Architecture and Landscape Section 4.55 Modification  
Port Macquarie Campus

Project	Hastings Secondary College	Code	HSPM
Organisation	FJMT	Revision	1
To	Bill Rushworth	Date	14/04/2022
		Doc Number	A-000055

scale	1:200 @ A1	first issued	12/2/21
project code	sheet no.	revision	
HSPM	SSDA-130031	07

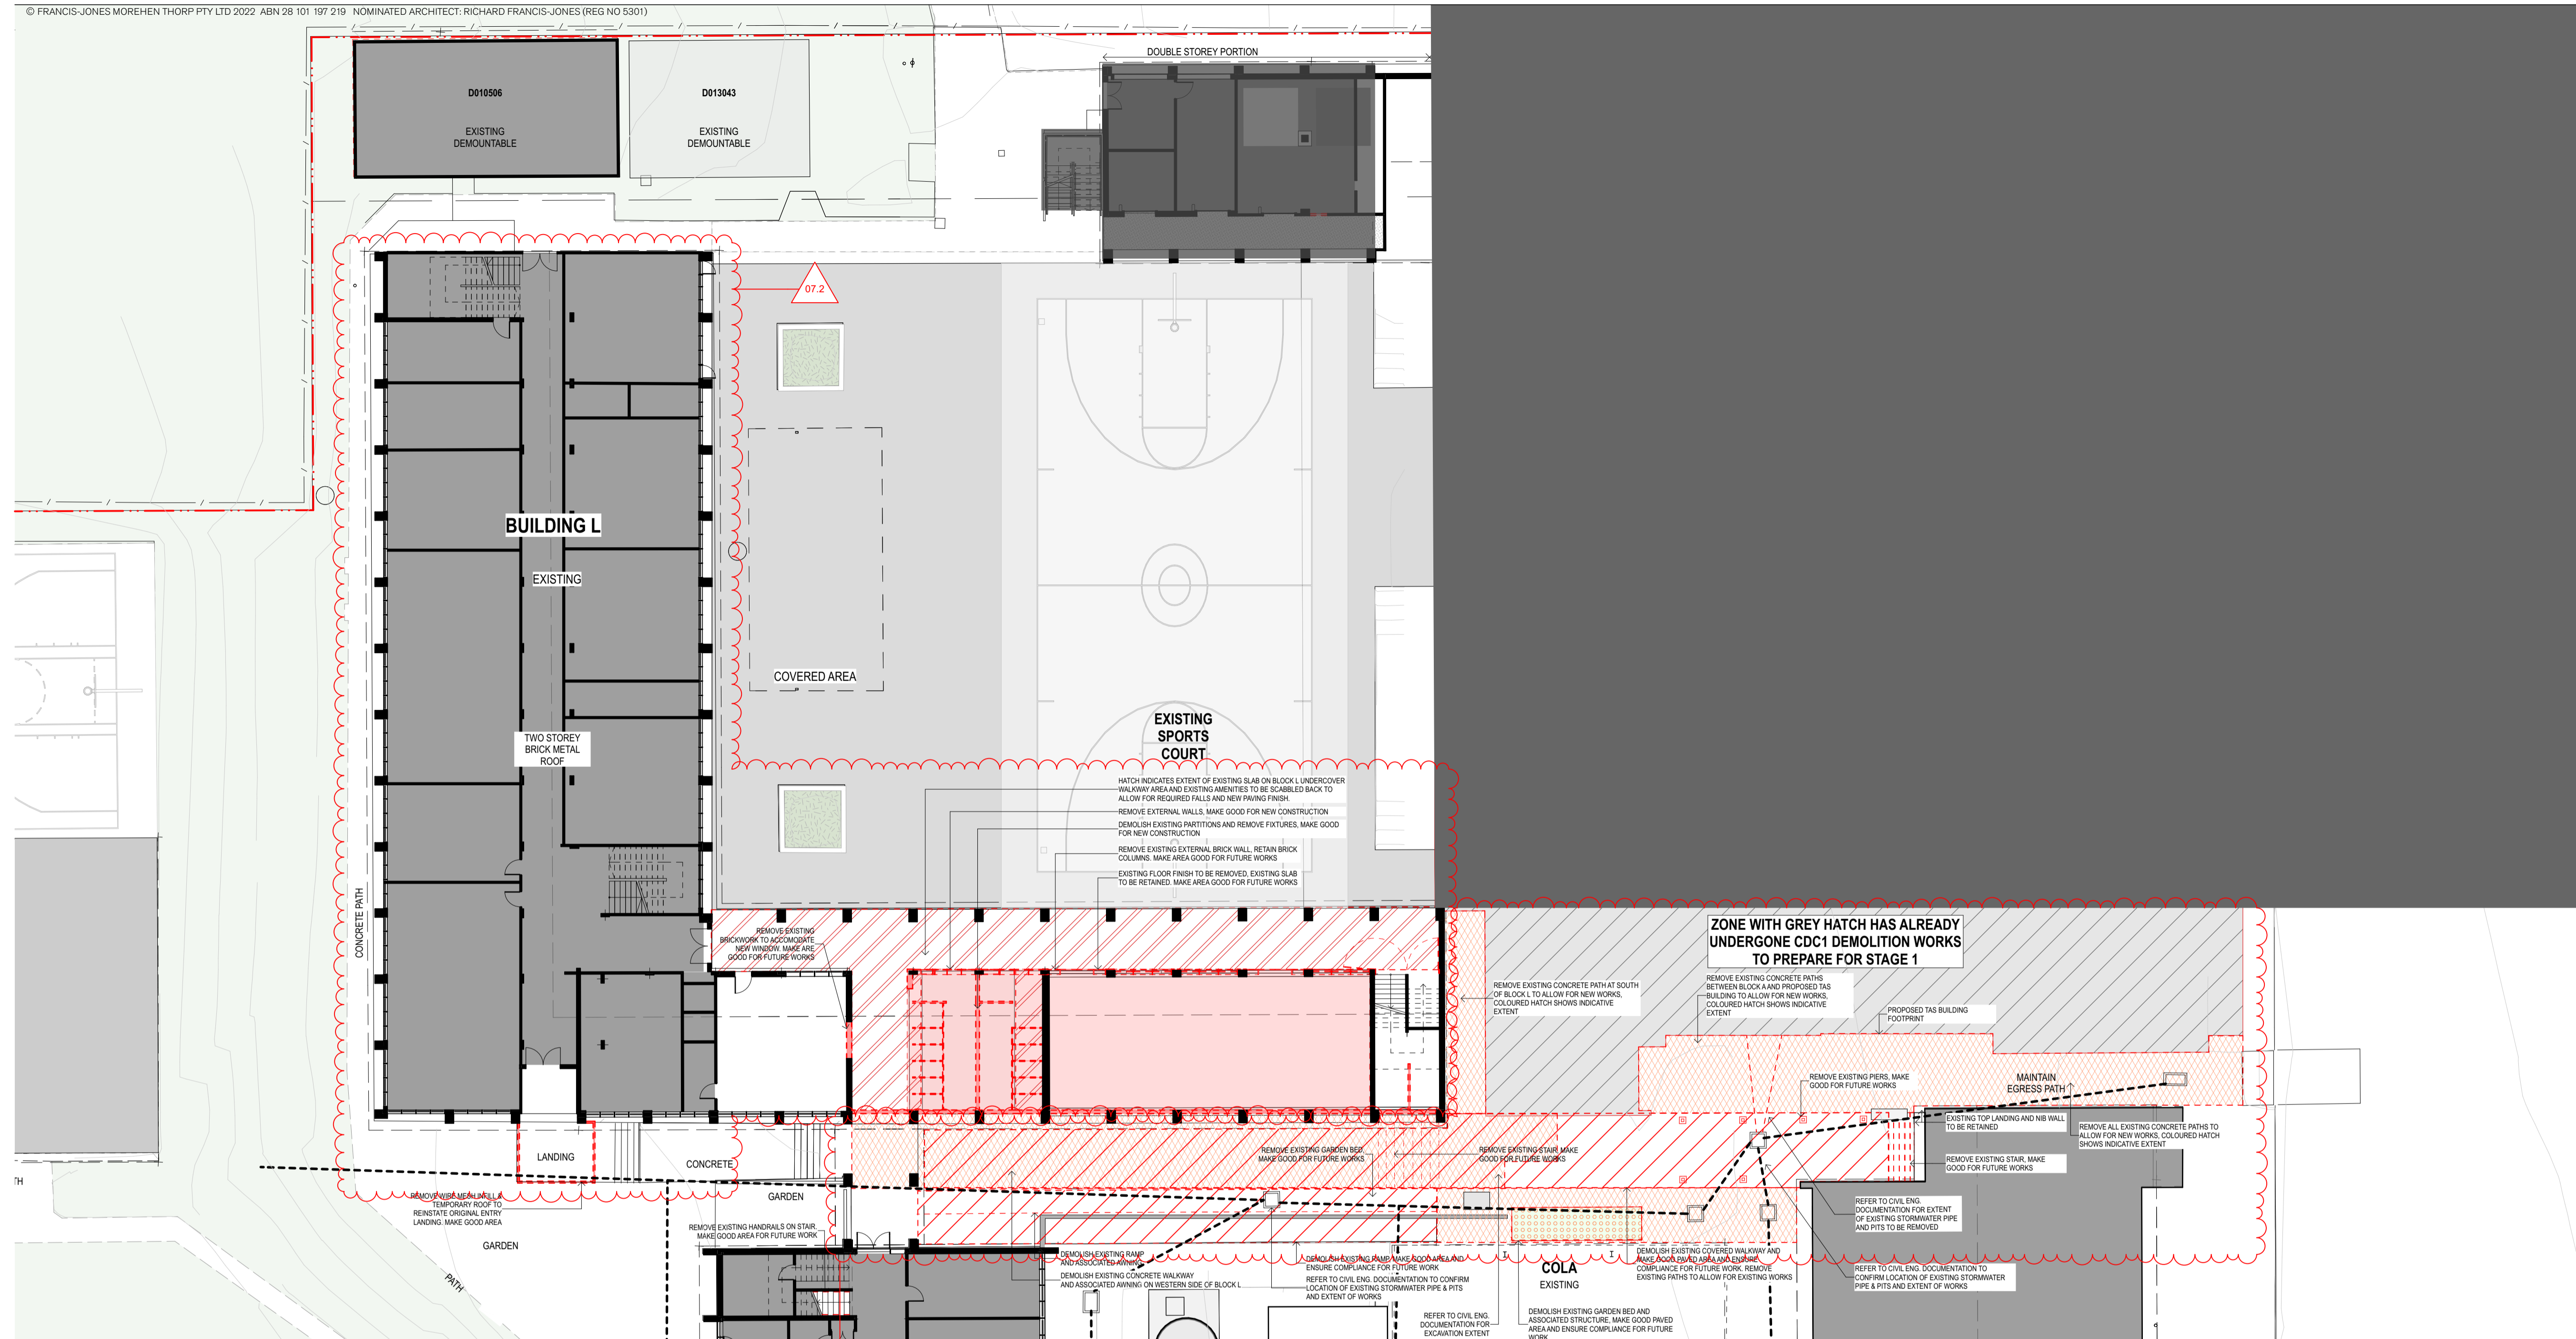
6.6	Relocation of Supported Learning (previously in Ground Level Building L) to provide a better connectivity with adjacent departments.
			6.7	Relocation of Supported Learning to provide a better connectivity with adjacent departments. No work to this zone.
13000 Site Demolition and Preparation				
SSDA 130031	07	Demolition Plan - Building L Ground Floor	7.1	Modification to layout of access stairs to avoid site services. (Grease arrestor). Extent in ground demolition revised.

7.2	No work to Ground Level Building L Northern Wing. Revised extent of demolition to Western Wing of Block L
SSDA 130032	07	Demolition Plan- Building L + Building B Ground Floor	7.1	Minor changes to all areas of demolition to meet existing site conditions and identified changes to General Arrangements. Ceiling fittings removed in Block B to allow for future works.

title
General Arrangement Plans 1:500
General Arrangement Plan - Site Plan 3

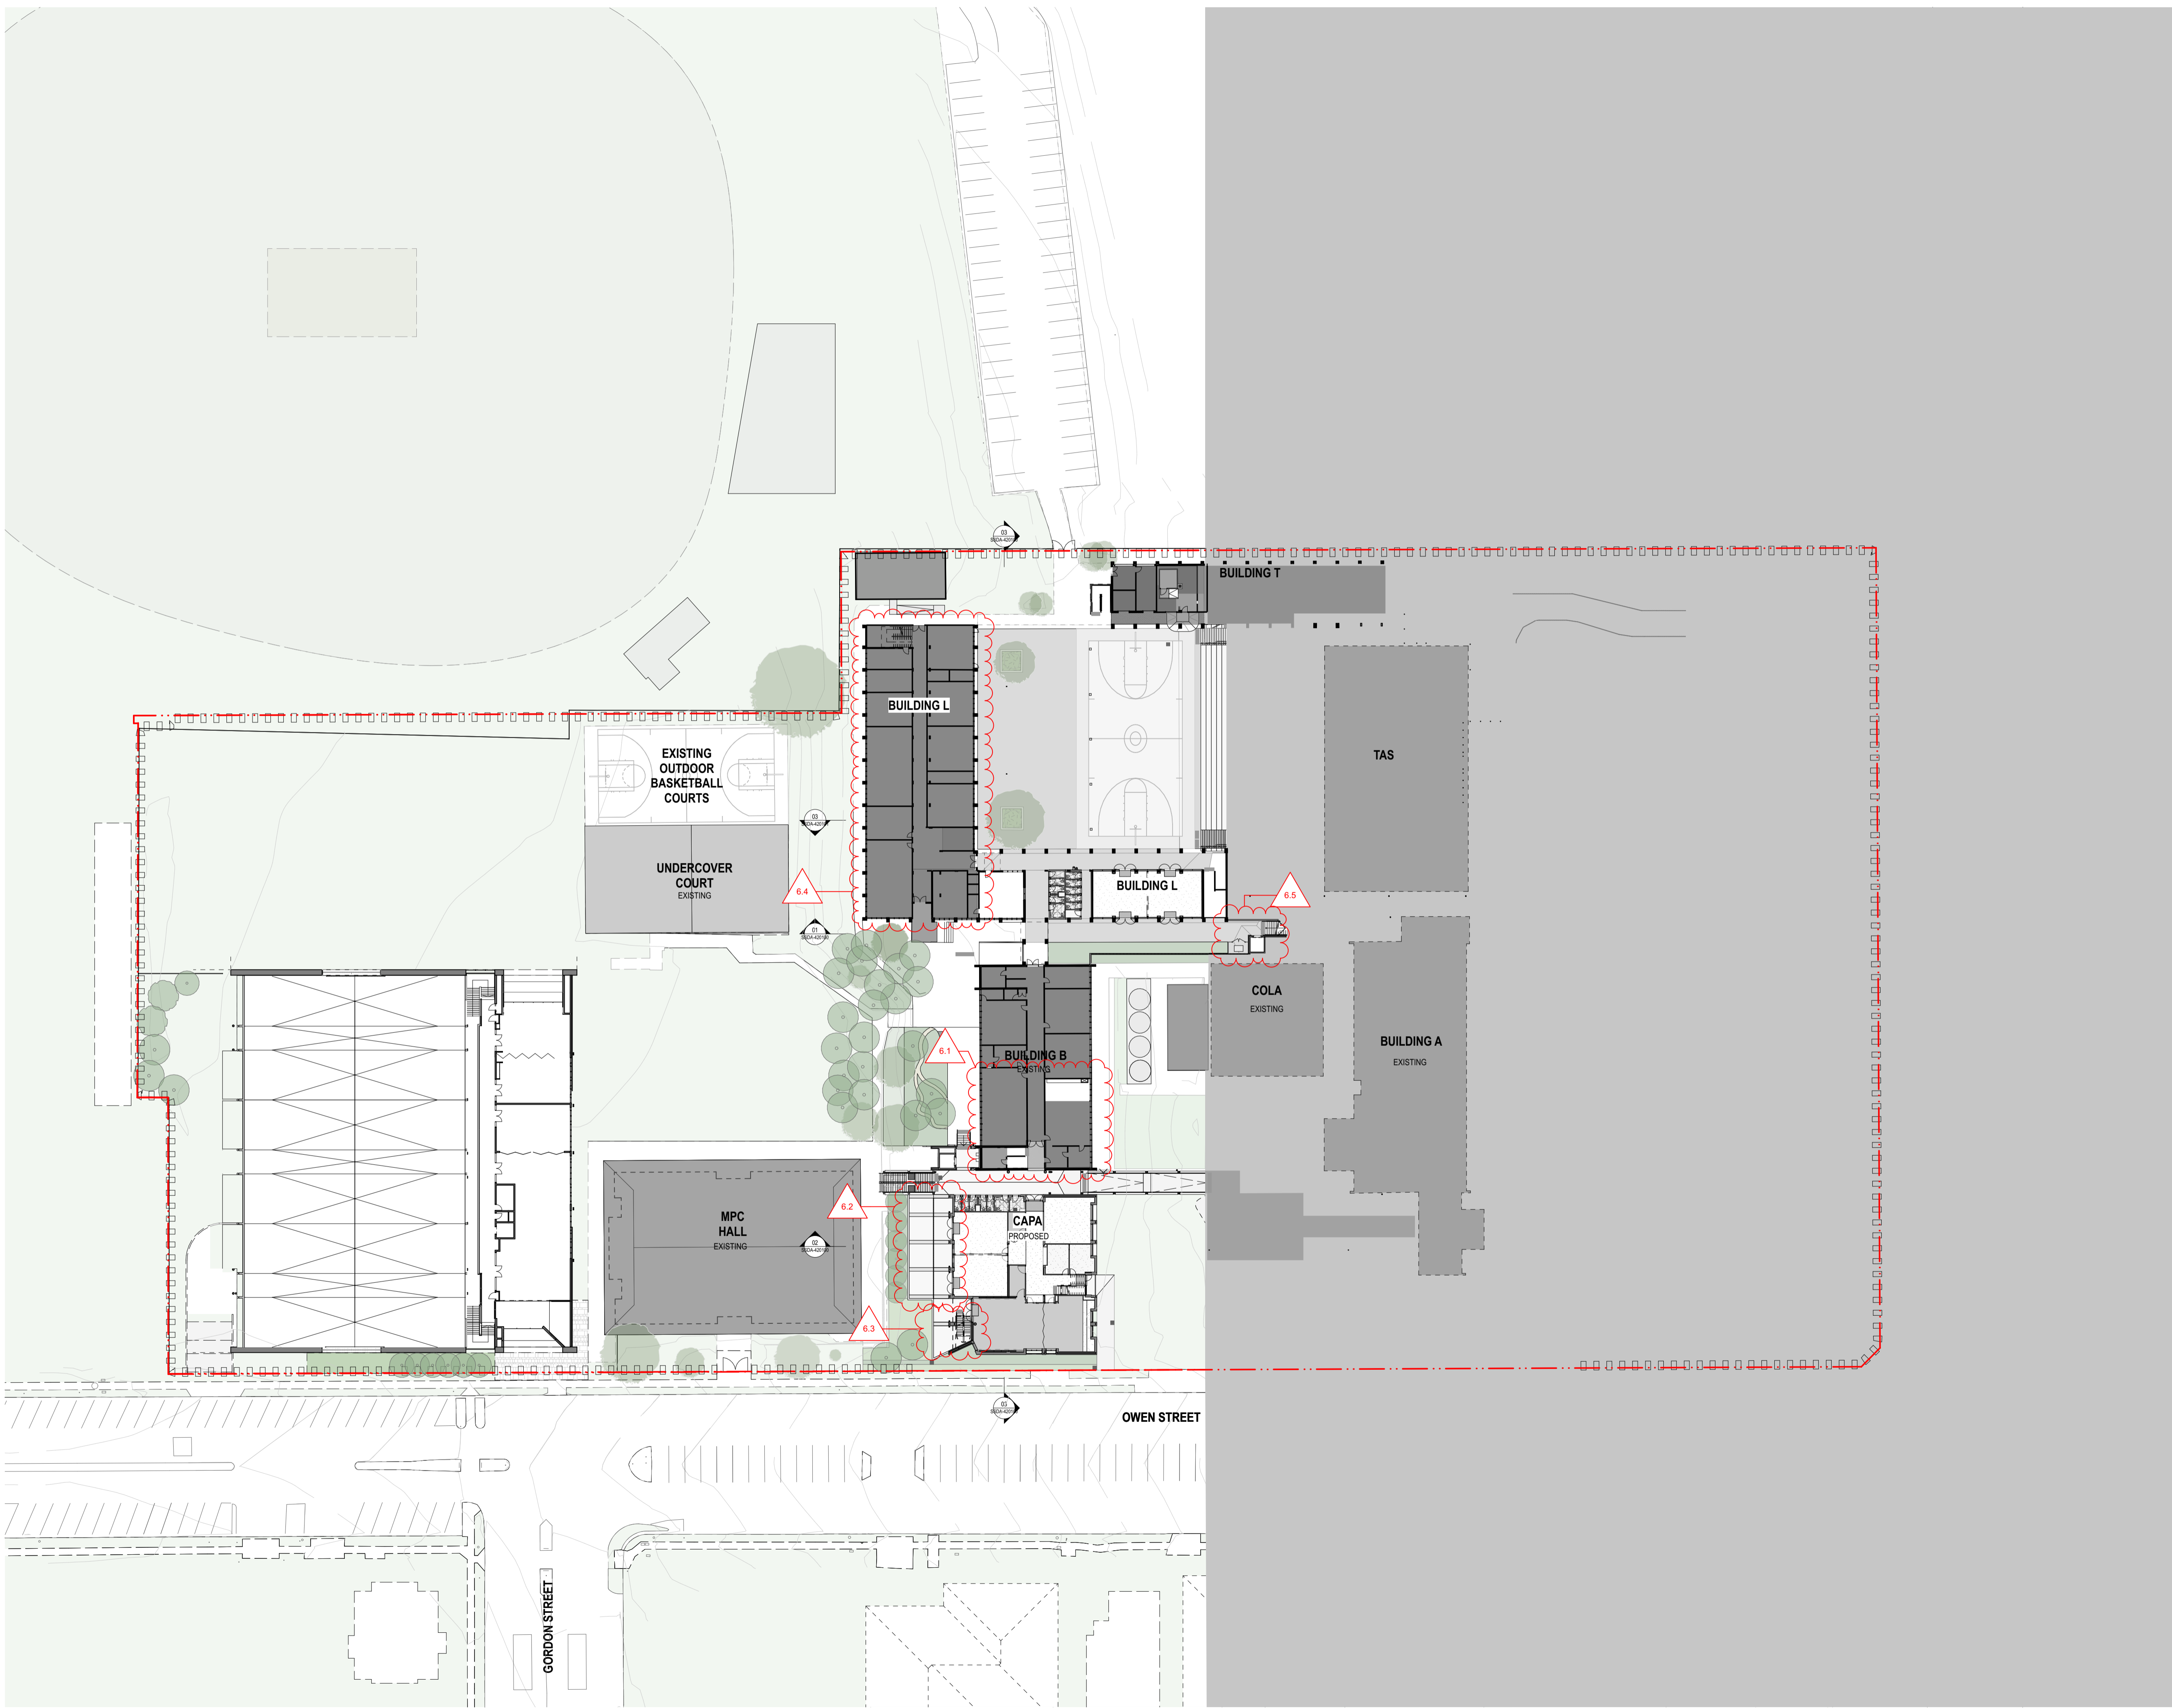
7.2	Removal of Block B internal partitions to meet new layout requirements. Change of demolition extent for linkway to Block L
20000 General Arrangement Plans 1:500				
SSDA 200002	06	General Arrangement Plan - Site Plan 3	6.1	Existing access/egress stairs and adjacent entrance and stores converted to an external zone to enable the consolidation of Building B and CAPA. New external doors relocated to east of the existing stairs. Existing internal finishes to be clad to meet exterior facade requirements. New Bulkhead and Services Duct reticulated through joinery from Level 1.

6.2	Materiality of external terrace revised from timber to inset coloured concrete screed for functionality.
			6.3	New painted steel egress stairs to access Level 1 terrace. Minor changes to the northern facade glazing to accommodate this change.

6.4	Relocation of Supported Learning to provide a better connectivity with adjacent departments. No work to this zone.
			6.5	Minor dimensional adjustment to lift. Materiality revised from off form concrete to brickwork and compressed fibre cement cladding.
SSDA 200003	05	General Arrangement Plan - Site Plan 4	5.1	New painted steel egress stairs to access Level 1 terrace. Minor changes to the northern facade glazing to accommodate this change.
